Subject: RE: *EXTERNAL: Barratt Temp Sales Office Applications (Y/31/21/PL & Y/32/21/A), Land at Drove lane, Yapton

Subject: *EXTERNAL: Barratt Temp Sales Office Applications (Y/31/21/PL & Y/32/21/A), Land at Drove lane, Yapton

Barratt Static Banner
Barratt Logo
Flags - 600mm x 2200mm

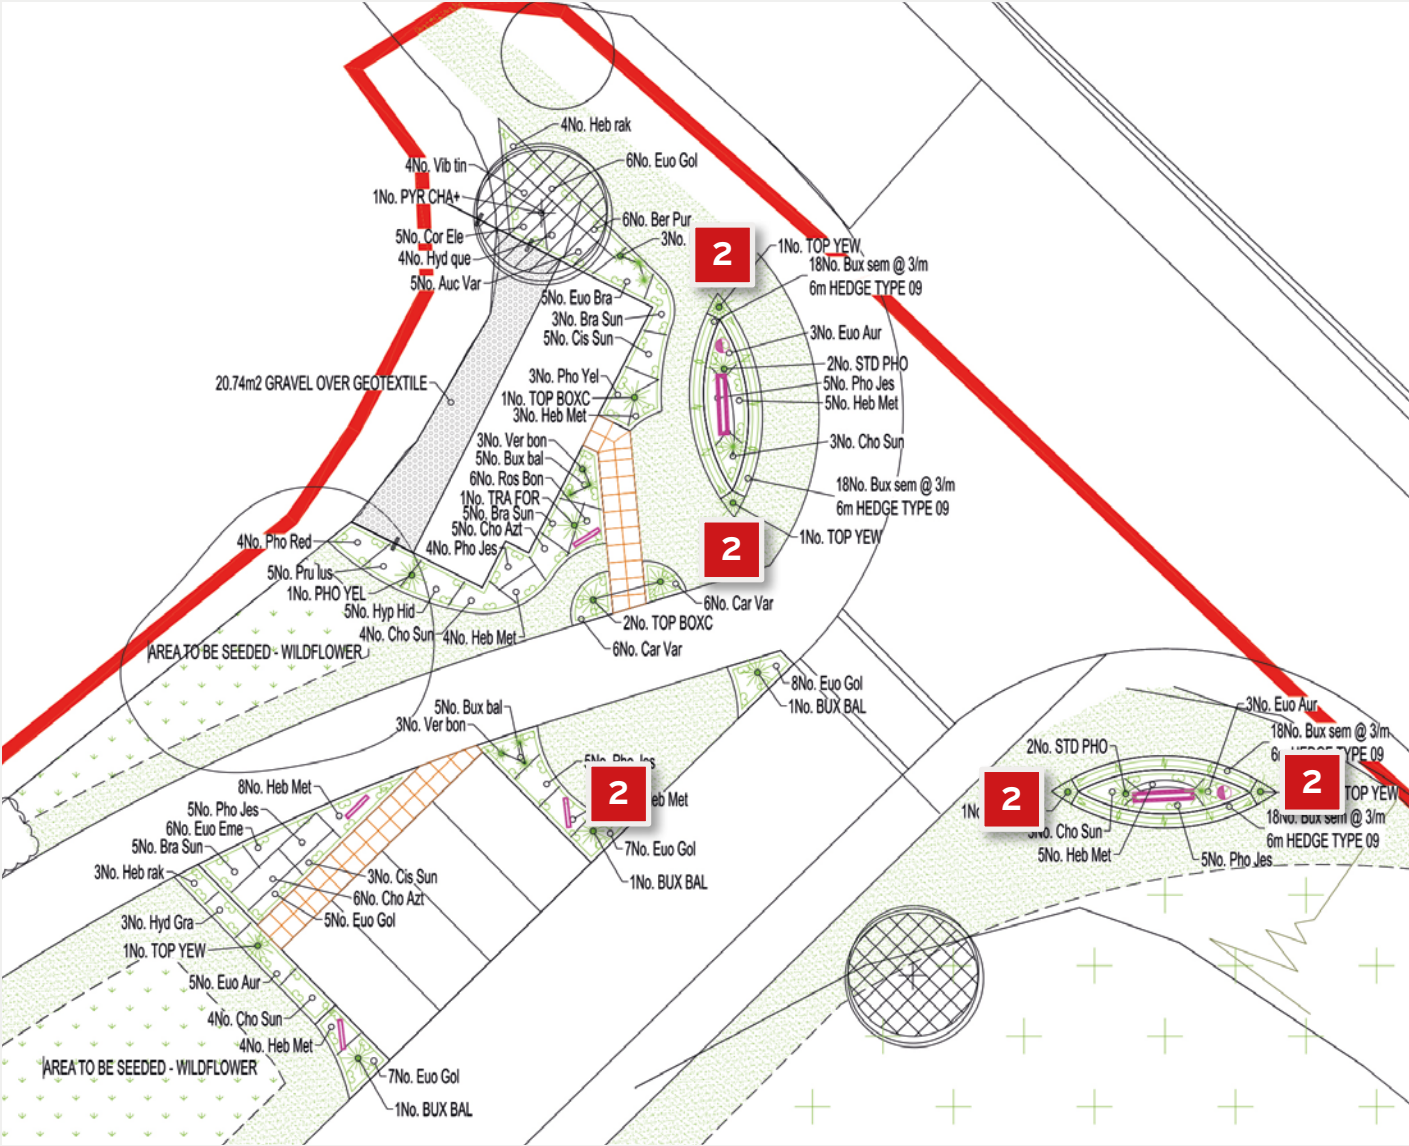
I don't believe that the Parish have just asked for a reduction in flags. Their comment is actually that the flags and freestanding sign should be sufficient which implies that they are objecting to all the other signage).

I write to alert you that it is our intention to refuse these two applications on the grounds of visual harm to the nearby heritage assets and to the character of the area/streetscene. You may also have noted on the application files the comments of our Conservation Officer and the Parish Council. I also consider that the amount of freestanding adverts/signs in the temporary area is excessive in such a sensitive location.

The Parish Council have commented that the proposed advertising is appropriate (albeit with reduction in flags which is entirely doable) but are concerned about the prominence of the sales cabin and would prefer this located within the main body of the site. We understand this comment but it is not feasible because the main site will be under construction, hence the request for a temporary sales cabin at the front of the site.

Before you draft your Officer reports next week can we please 'meet' over a Microsoft Teams call or similar. There is no need for the two applications to be refused when we are happy to make changes in order to meet your satisfaction when we know what it is you want. Paragraph 38 of the NPPF specifically mentions that "*Local Planning Authorities should approach decisions on proposed development in a positive and creative way... and work proactively with applicants...*". The above concerns can be easily resolved through discussion between Arun DC and BDW rather than cause unnecessary negativity and delay. We have had positive dialogue on other sites in Arun and it has made the whole process a lot easier so hope that we can agree a revised approach comprising a reduction in signage and revised timeframe to everyone's benefit.

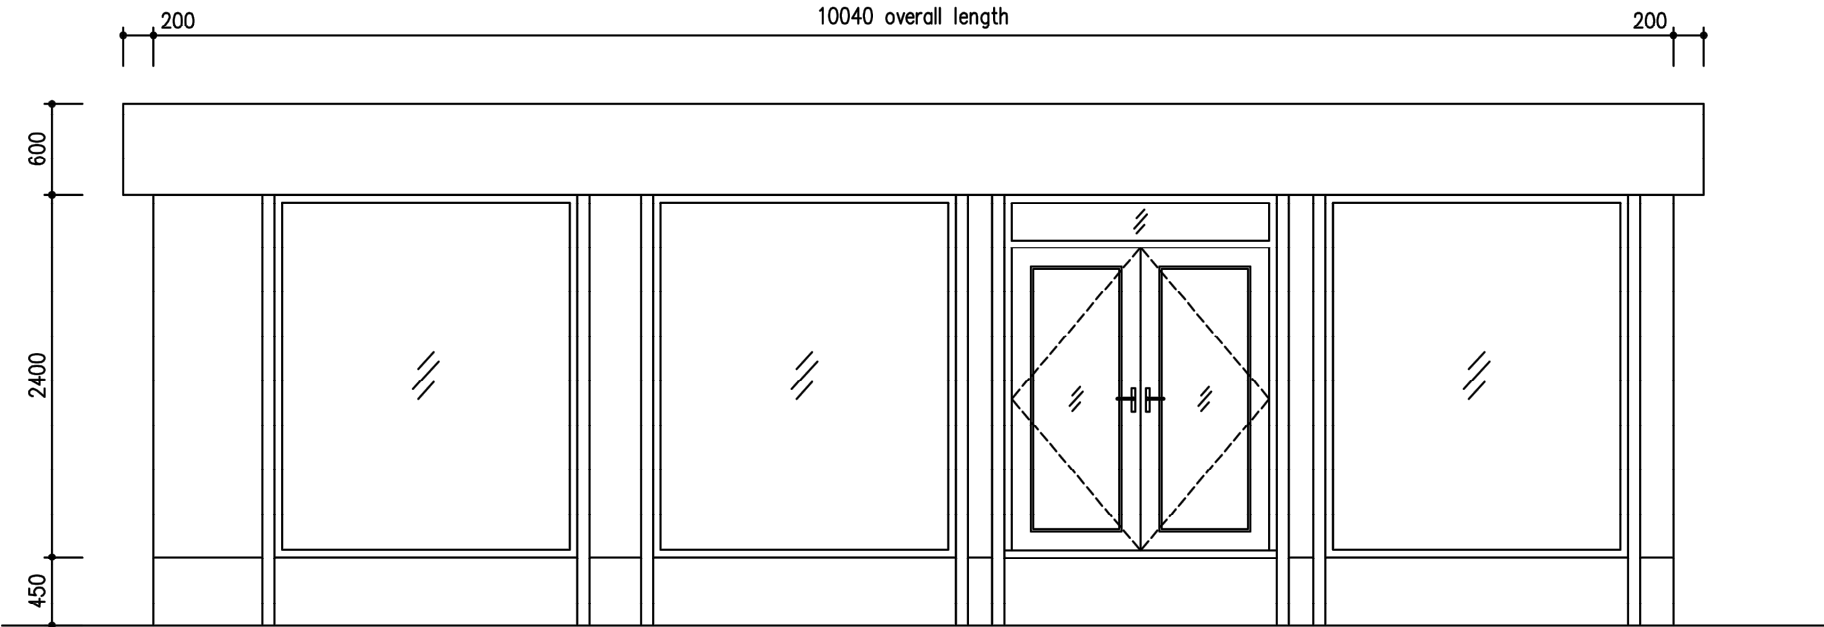
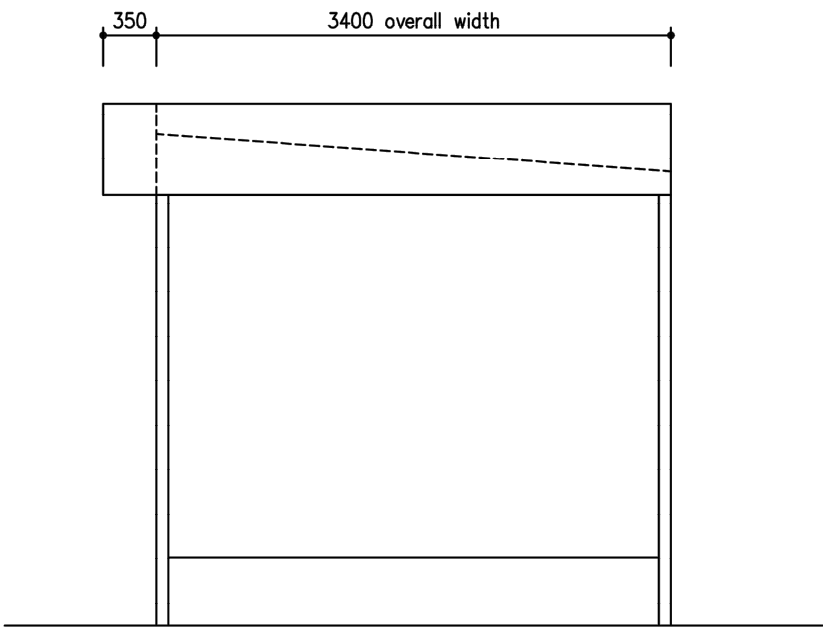
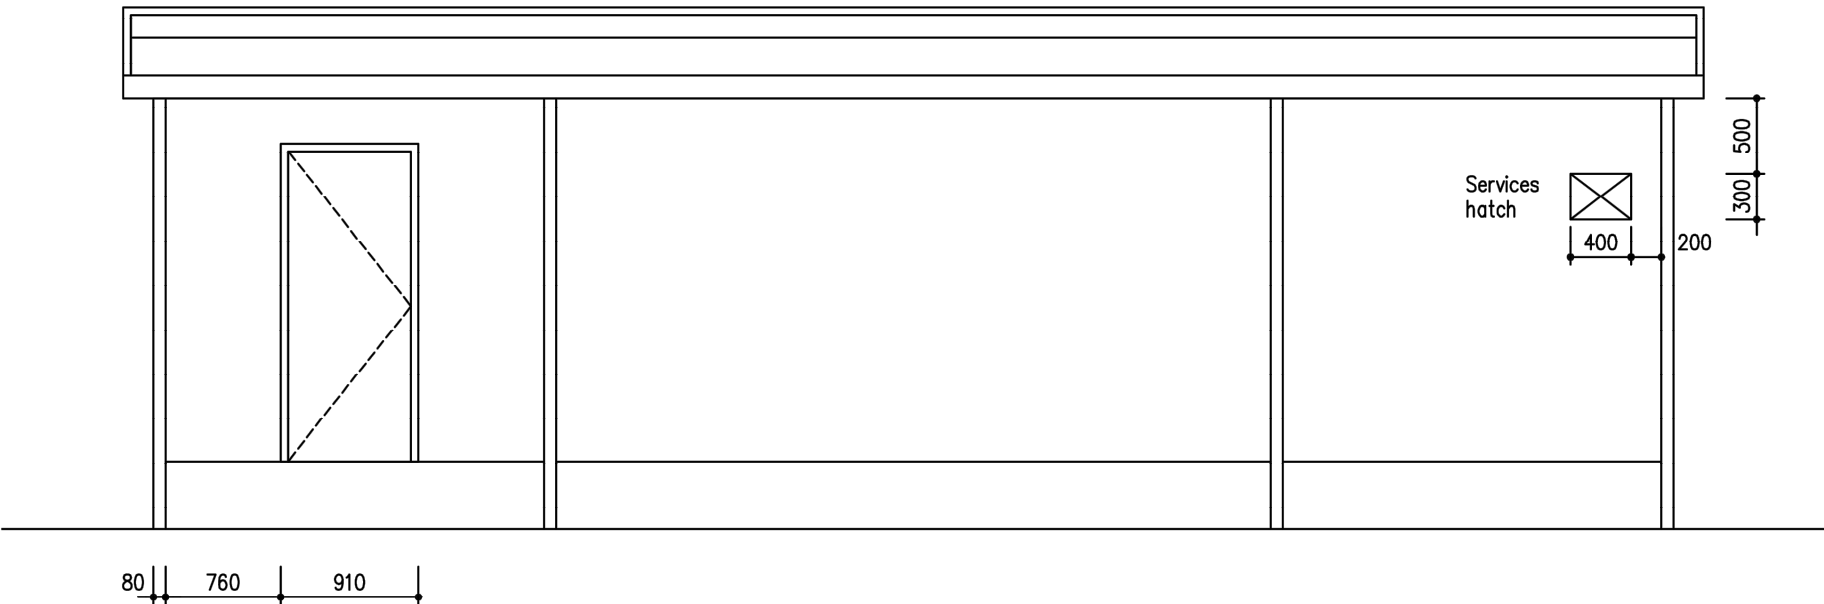
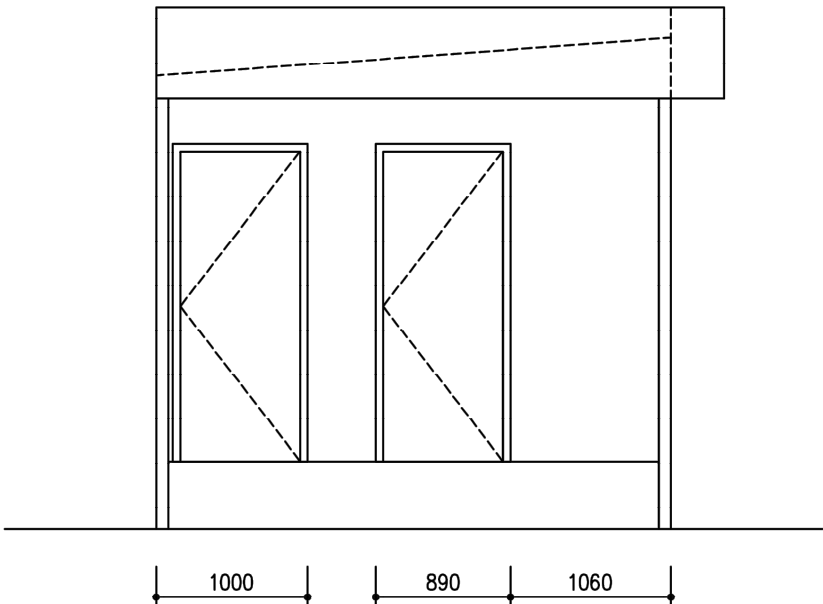
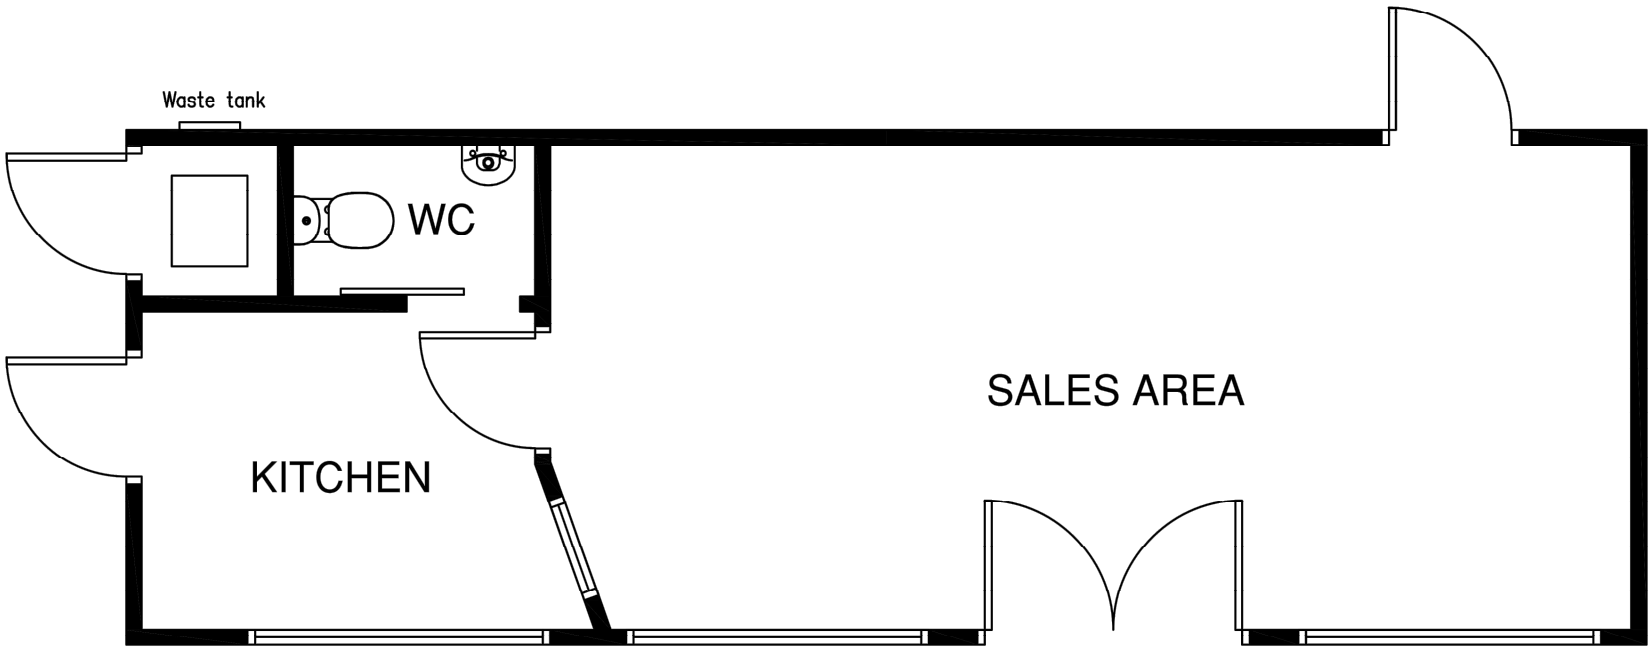
The Conservation Officer is aware of the wider context/the approved outline planning permission. However, as you can see he has concluded *less than substantial harm* and in order to resolve this, it would be necessary to demonstrate the public benefits of the proposed cabin. We would not be able to consider the benefits of the 300 houses in this determination and we can't consider private benefits. On this basis, I do not consider that this harm can be resolved.

Could you not relocate the temp sales cabin into the site such as in the locations on the attached I have suggested with the red star? There may be other areas within the site where it could go without affecting construction. If you are willing to look at such other options by withdrawing and engaging with me before a resubmission then I believe that we can come up with a solution that is mutually acceptable.
